Harnett County

PERMIT NUMBER
BCOM2509-0006

Description: 80 x 24 Pole Barn for storage at SJF Holdings			
Type: BUILDING COMMERCIAL	Subtype: STORAGE AUTO REPAIR SHOPS MINI STORAGE	Status: RECEIVED	Applied: 9/16/2025 DJ
Parcel No: 9691-33-4886.000	Site Address: 11948 US 421 N BROADWAY,NC 27505		Approved:
Subdivision: None	Block:	Lot:	Issued:
Lot Sq Ft: 0	Building Sq Ft: 0	Zoning:	Finalized:
Valuation: \$0.00	Occupancy Type:	Construction Type:	Expired:
No. Buildings: 0	No. Stories: 0	No. Unites: 0	
Details:

DESIGNED BY:	JEH
DRAWN BY:	JEH
APPROVED BY:	JEH
SHEET:	C2.01
CIVIL

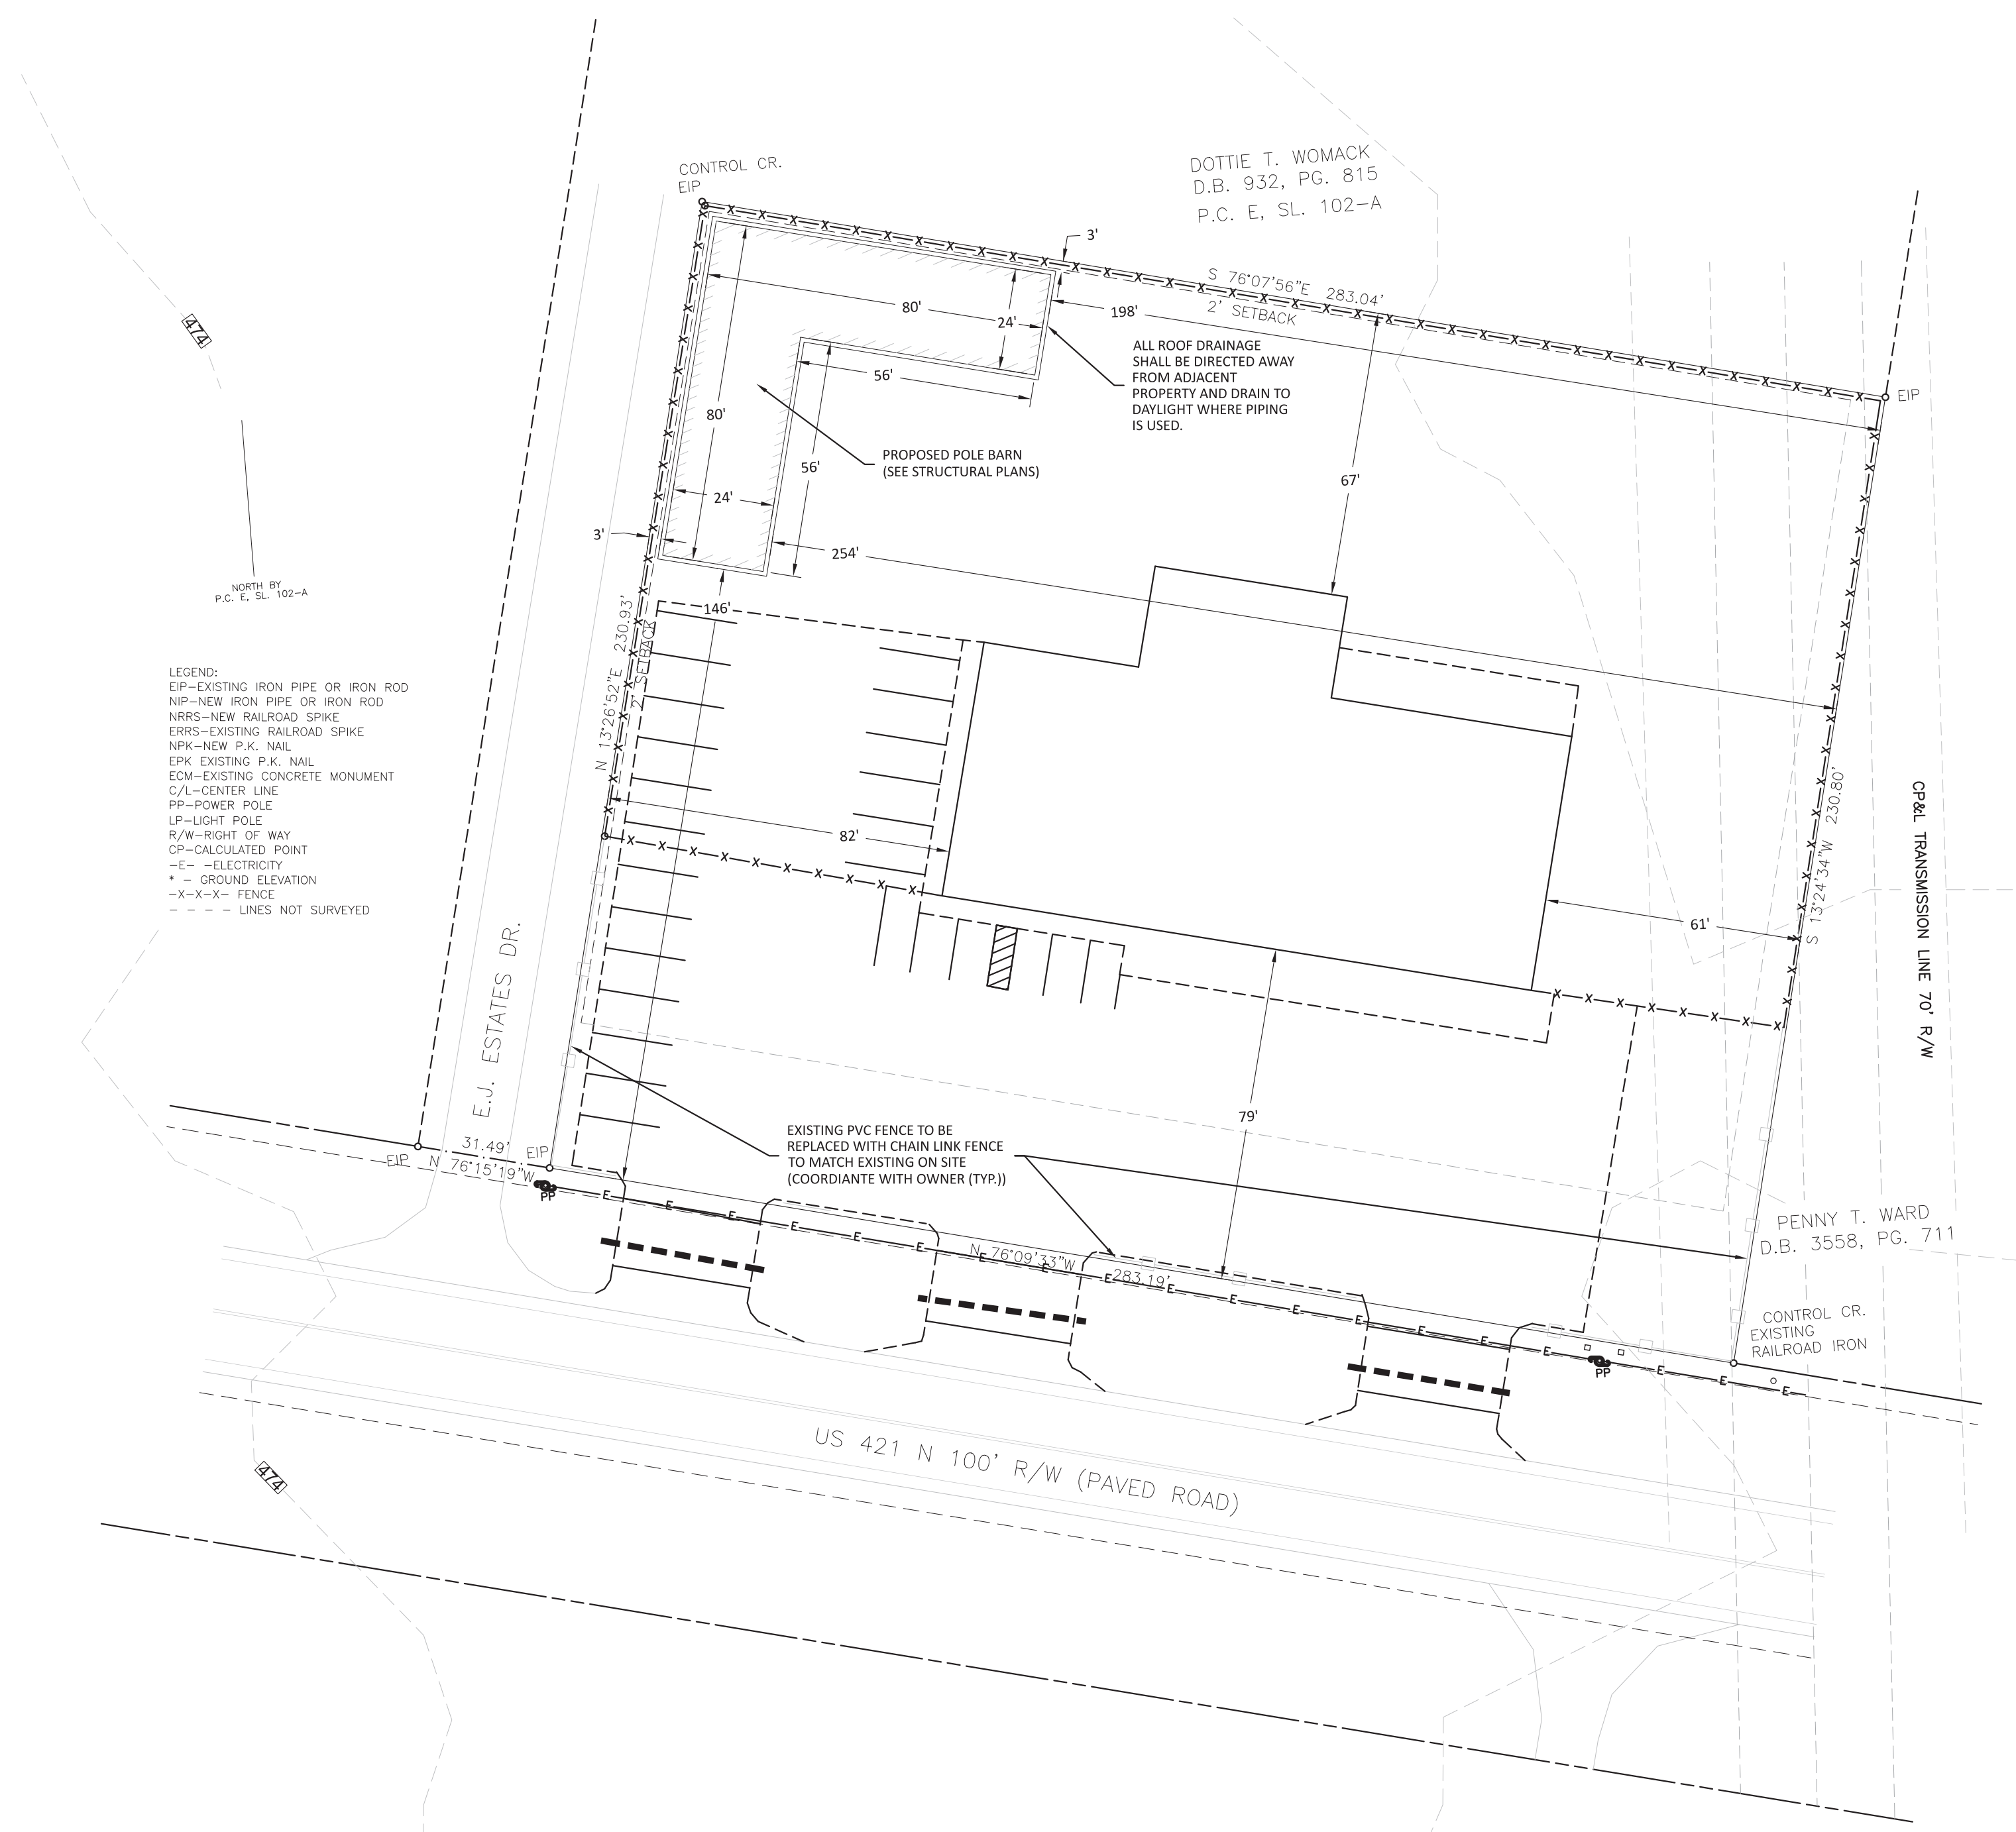
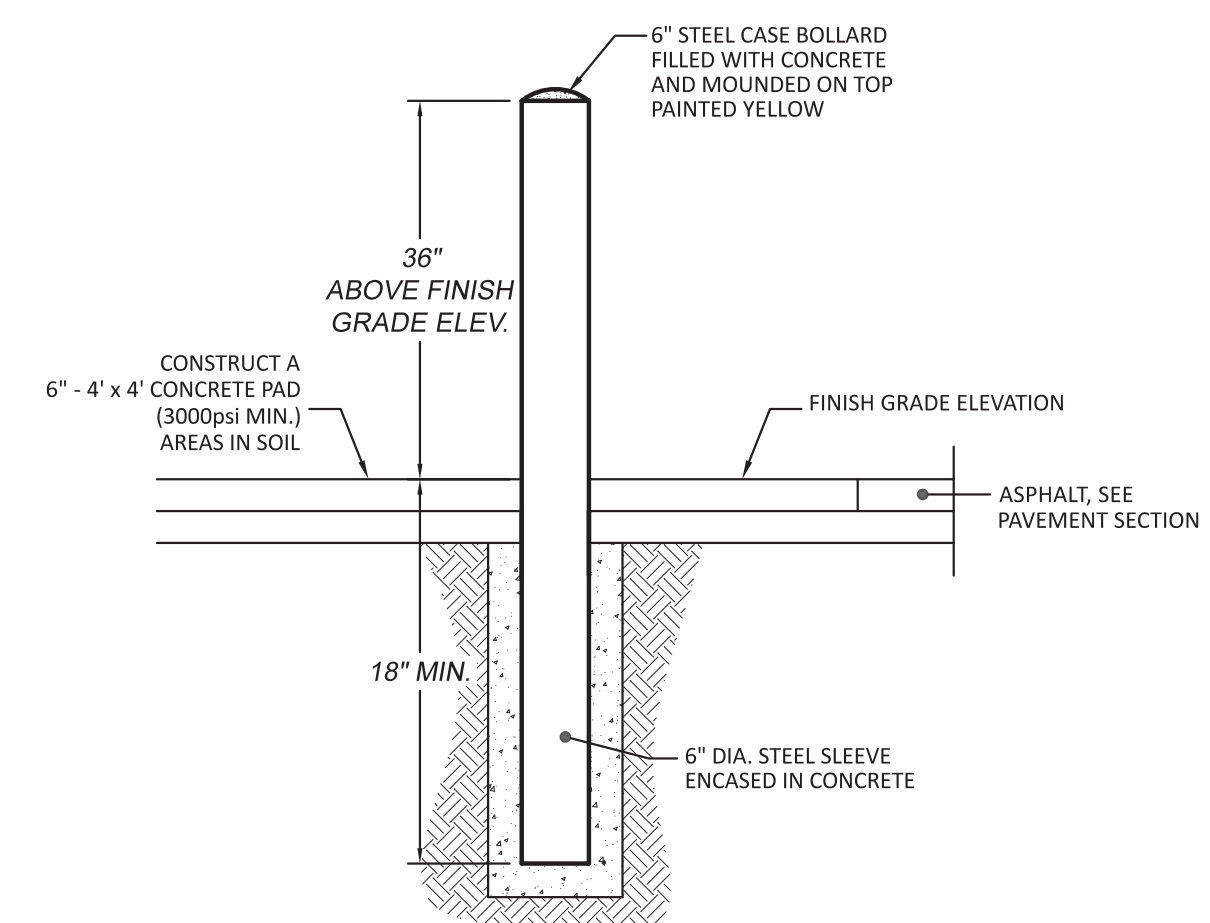
COMMERCIAL INTAKE	CP Bucket	9/16/2025		9/16/2025	APPROVED		
COMMERCIAL BUILDING REVIEW	Brad Sutton	9/16/2025	9/30/2025	9/17/2025	DISAPPROVED		Exterior walls/structure less than 10 feet from the property line shall be rated in accordance with Table 602 2018 NCBC
FIRE MARSHAL	Roger Sullivan	9/16/2025	9/30/2025	9/17/2025	APPROVED	see attached letter	See attached letter.
COMMERCIAL BUILDING REVIEW	Building Bucket	9/17/2025
